OFFICIAL NOTIFICATION OF DECISION

July 12, 2012

Project# 1002229
12EPC-40035 Site Development Plan for
Building Permit
12EPC-40036 Zone Map Amendment (Zone
Change)

for all or a portion of lot A-1, Tannehill-Taylor
Addition, located on 9900 Montgomery
Boulevard, containing approximately 3 acres.(G-
21)

A1 SITE DEVELOPMENT PLAN FOR BUILDING PERMIT
1" = 30'-0"

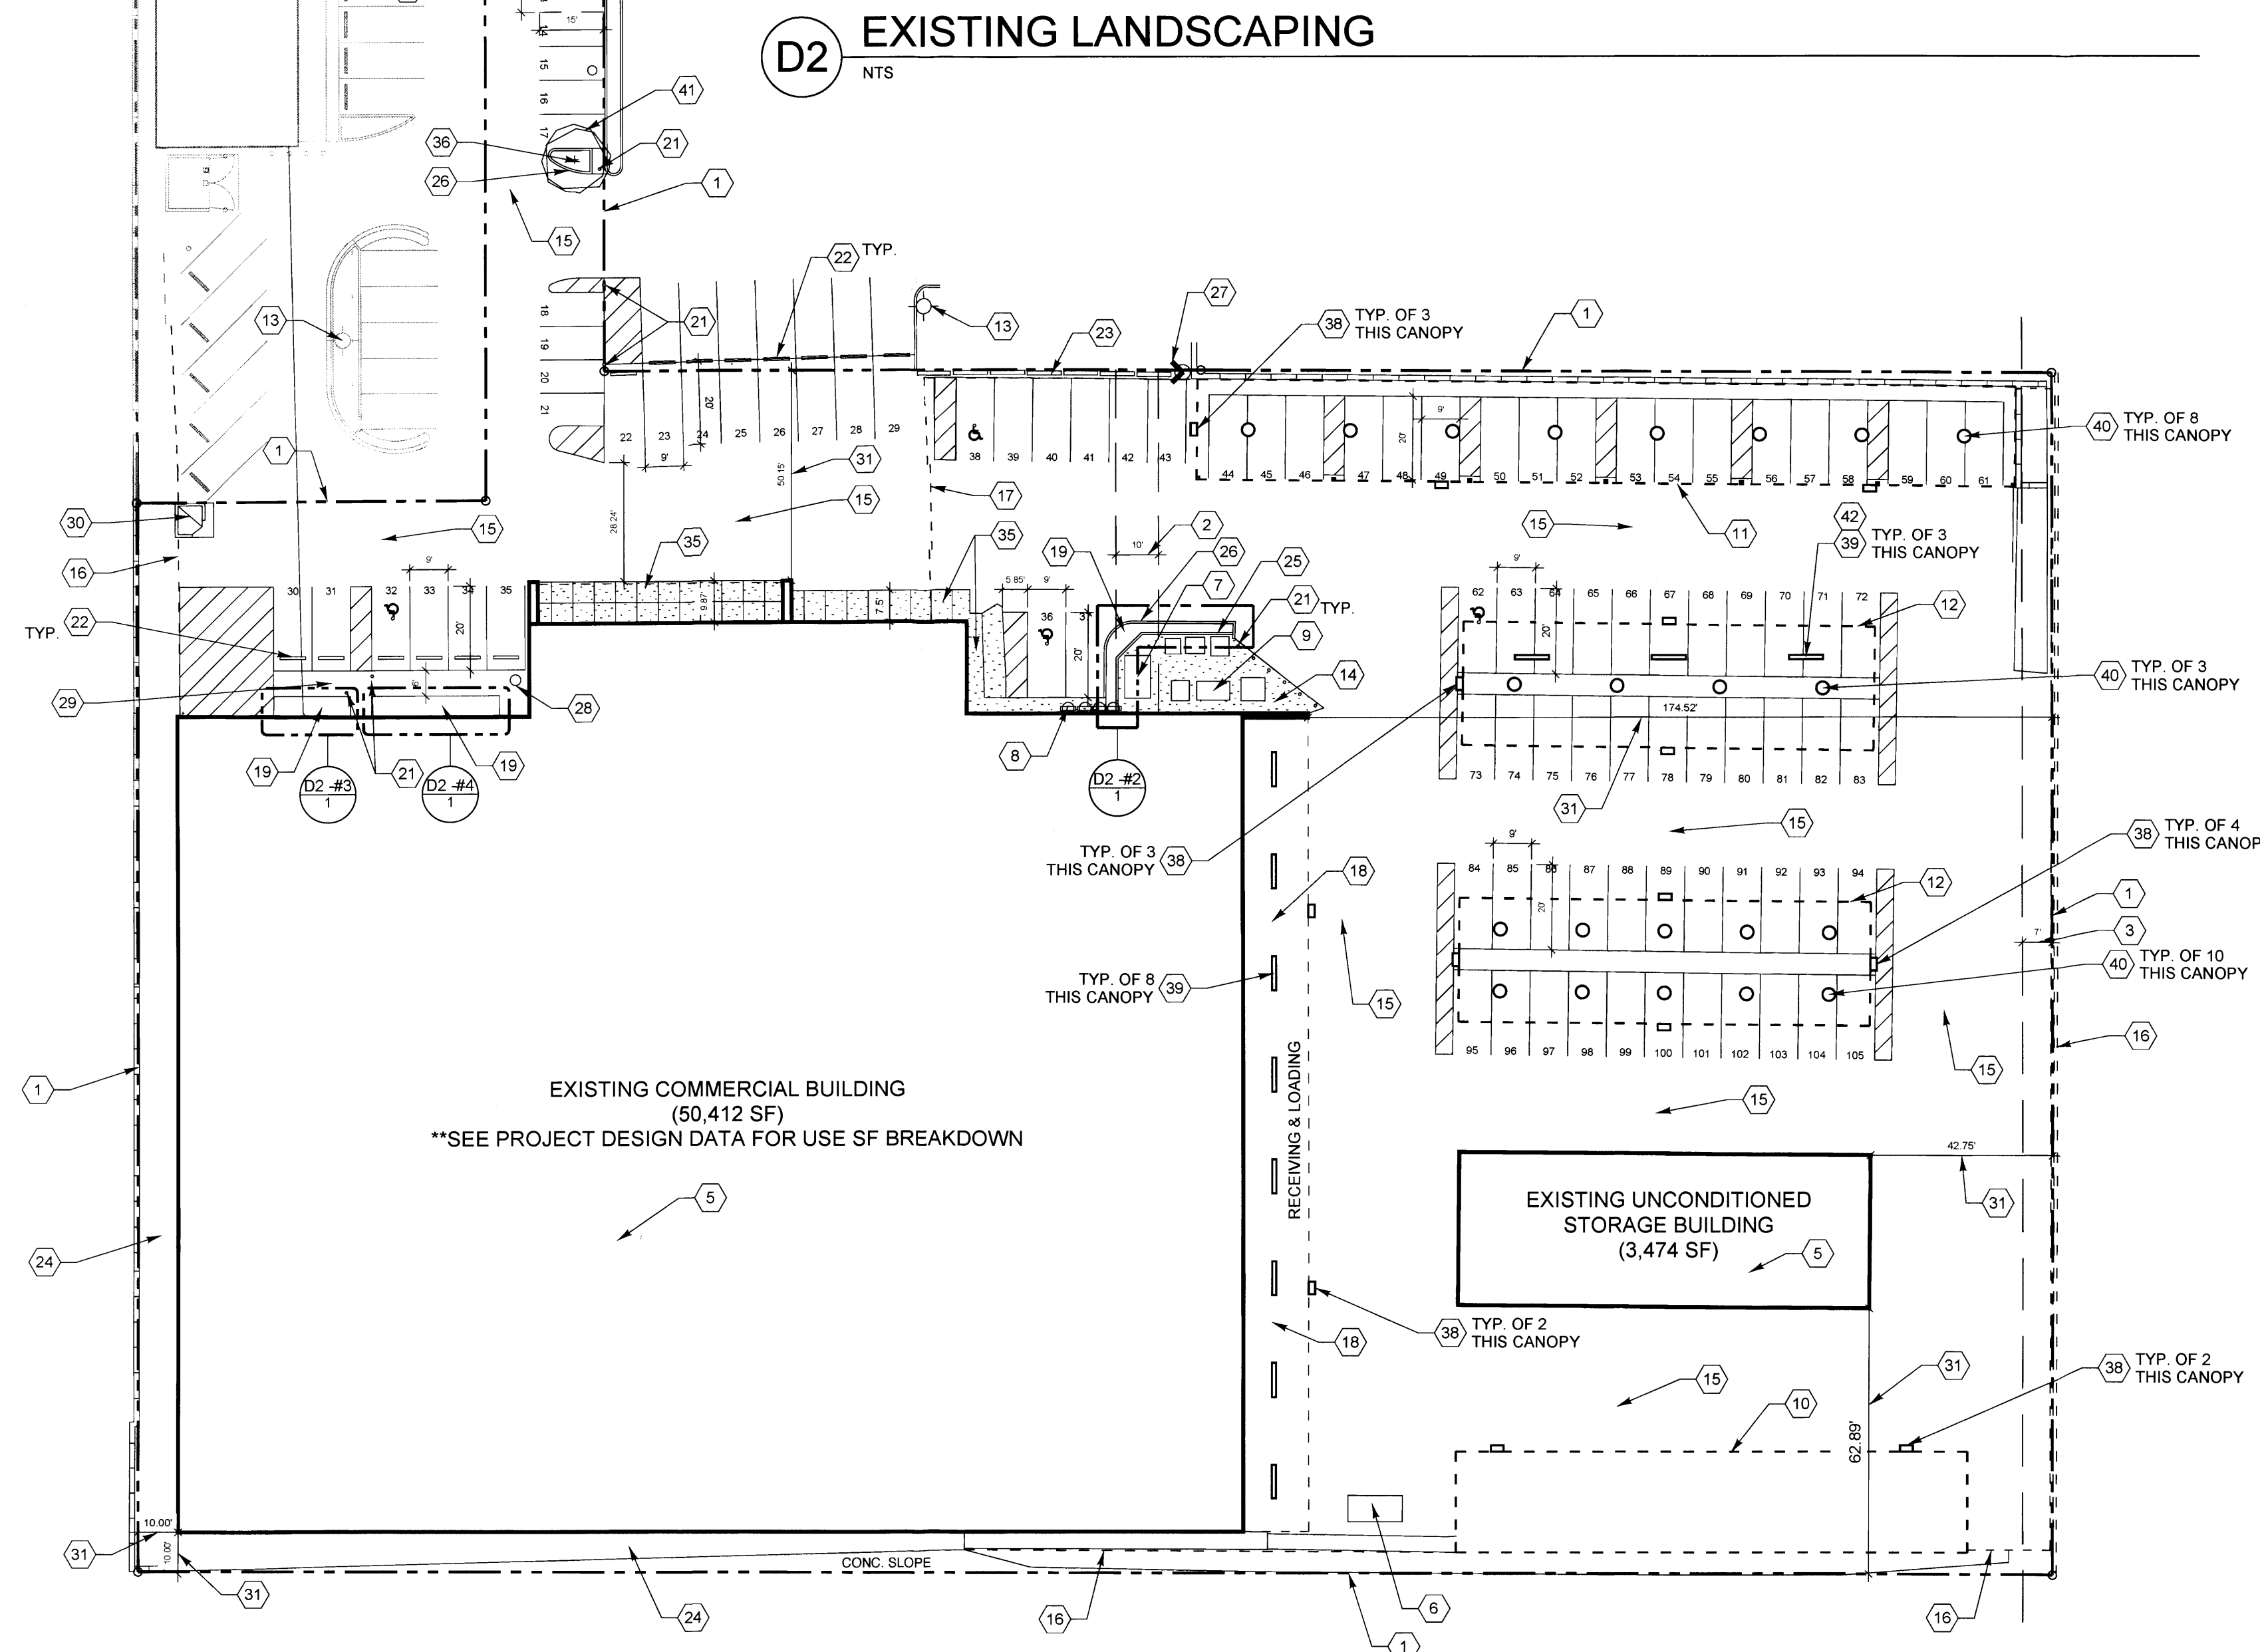
11. The EPC respectfully requests the applicant add landscaping where feasible and consider removal of the barbed wire fence.

4. The applicant shall demonstrate that there is adequate lighting for the parking areas and the loading docks and provide security to the general area. Additional lights may be required.
